From: Martyn White
Sent: 05 October 2018 10:07
To: Planning.Responses
Cc: Anita Gardner
Subject: A/106/18/PL

A/106/18/PL

The application affects an attractive property along the high Street in Angmering. It is requesting a change of use of the Old Bakery to be used as a self-contained annexe for family dependents & a holiday let, plus the construction of a new vehicle crossover and off-street parking for 2no cars.

client	project	drawing	date	drawn	drawing no	revision
Julie Cleasby	Change of use at Somerset House, High Street Angmering, BN16 4AG	Location & Site / Block Plan	Mar 18	pd	0225 / 101	C
			scale	CAD file name:		
			1:200, 1:100, 1:1250 @ A3

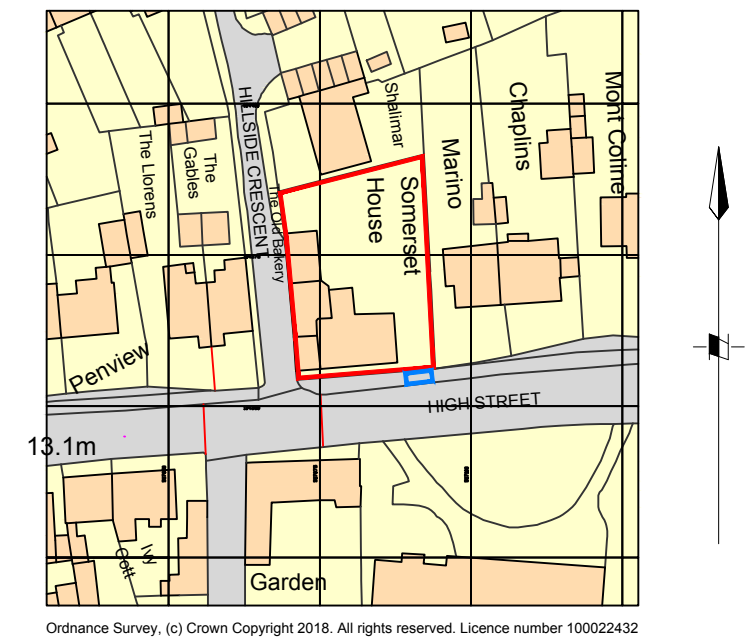
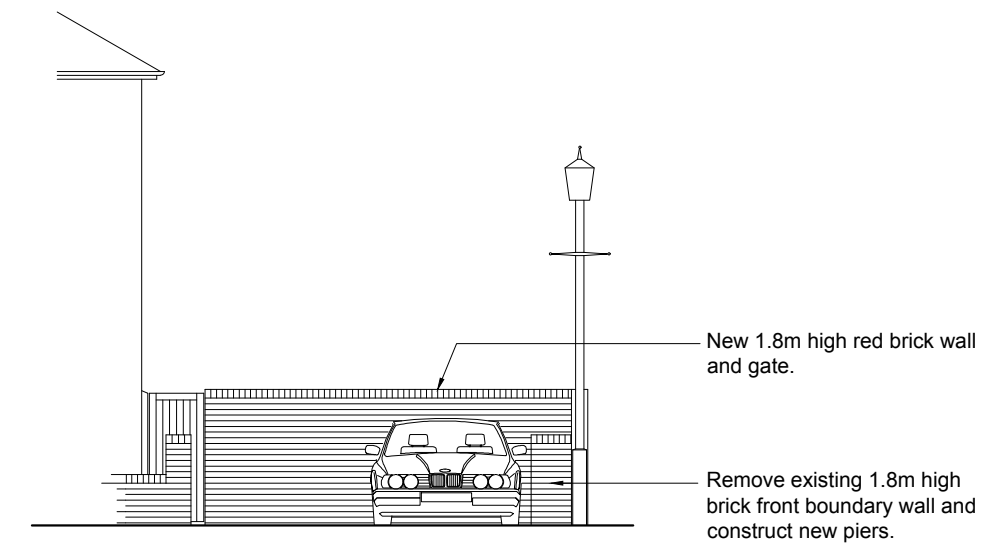
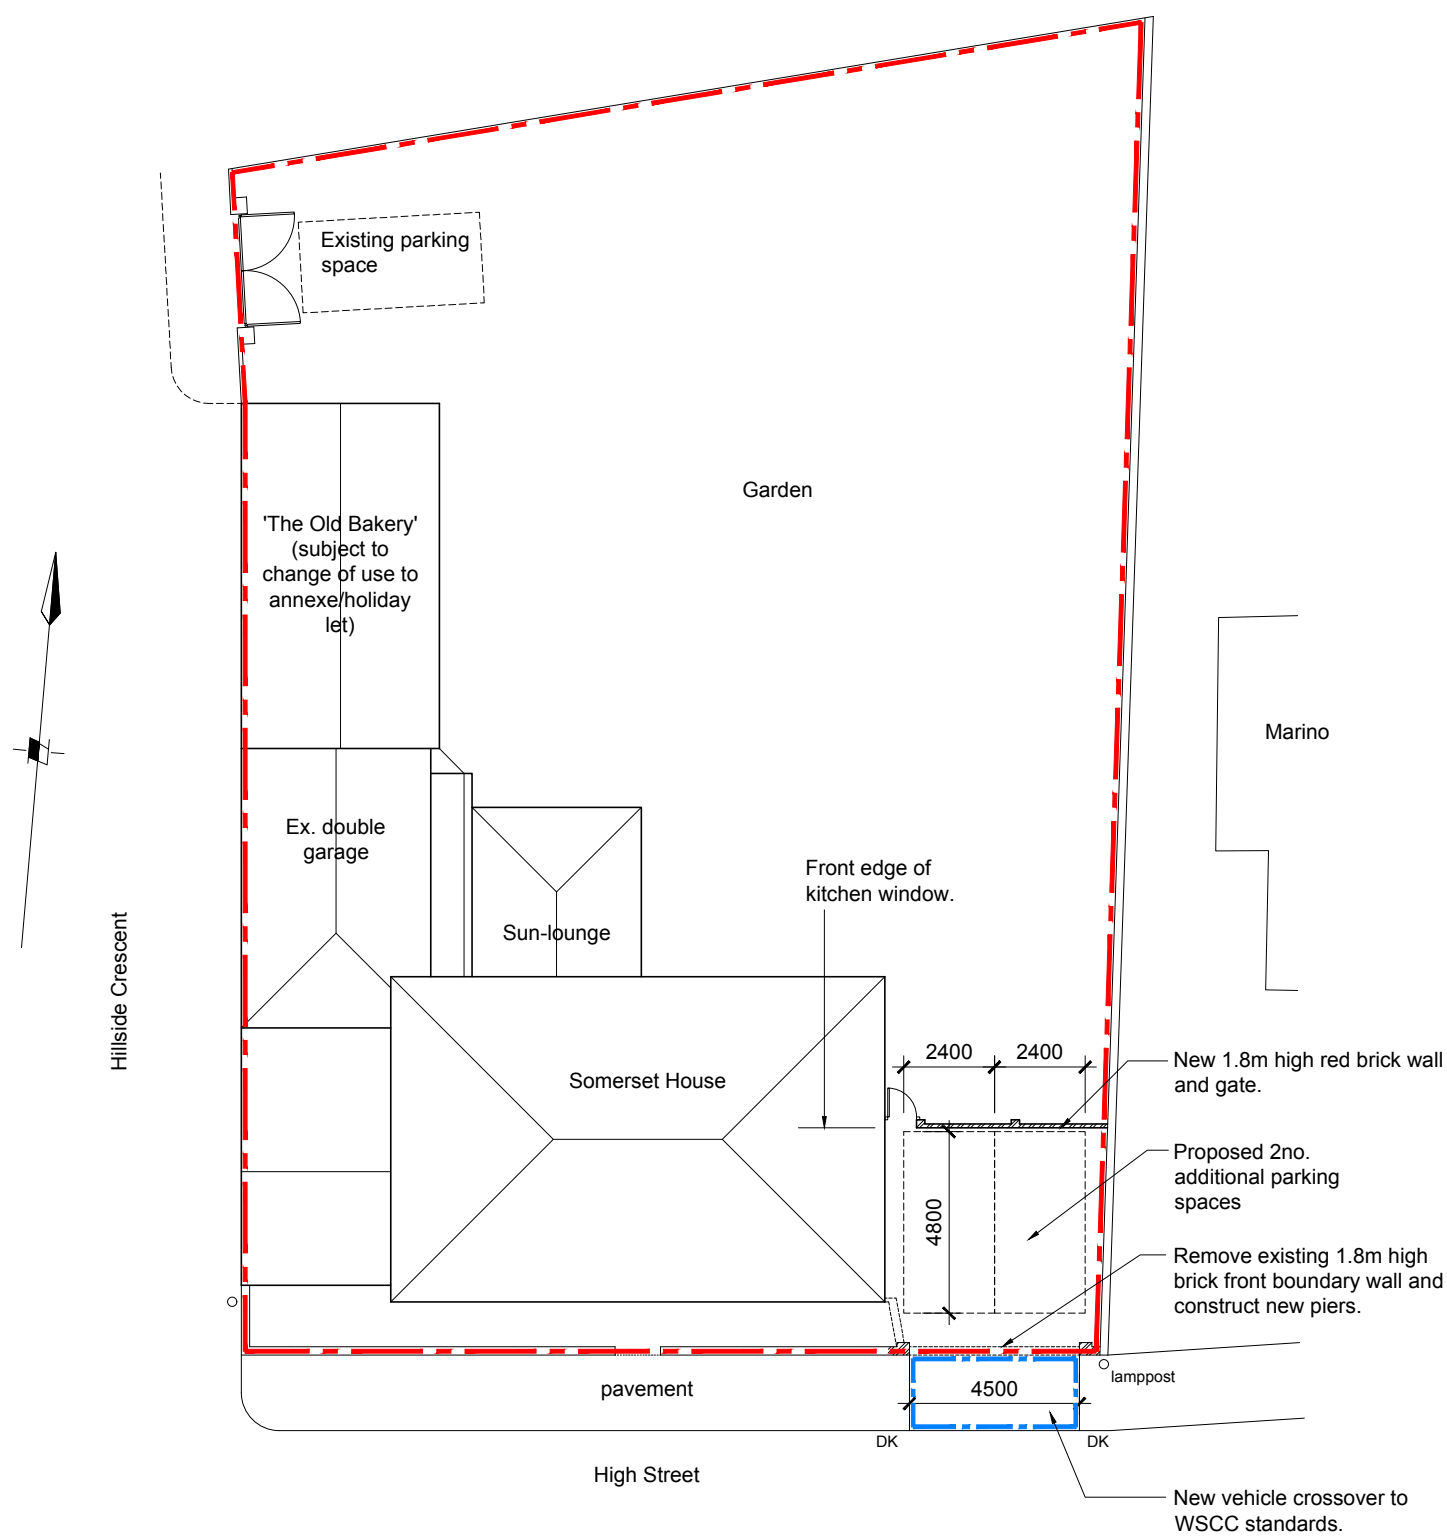
The provision of the off street parking is, also problematic, as it results in the loss of an attractive feature on the street-scene, which forms part of the enclosure of the street. The provision of walling adjoining the pavement is a feature of surrounding properties, and its loss cannot be supported.
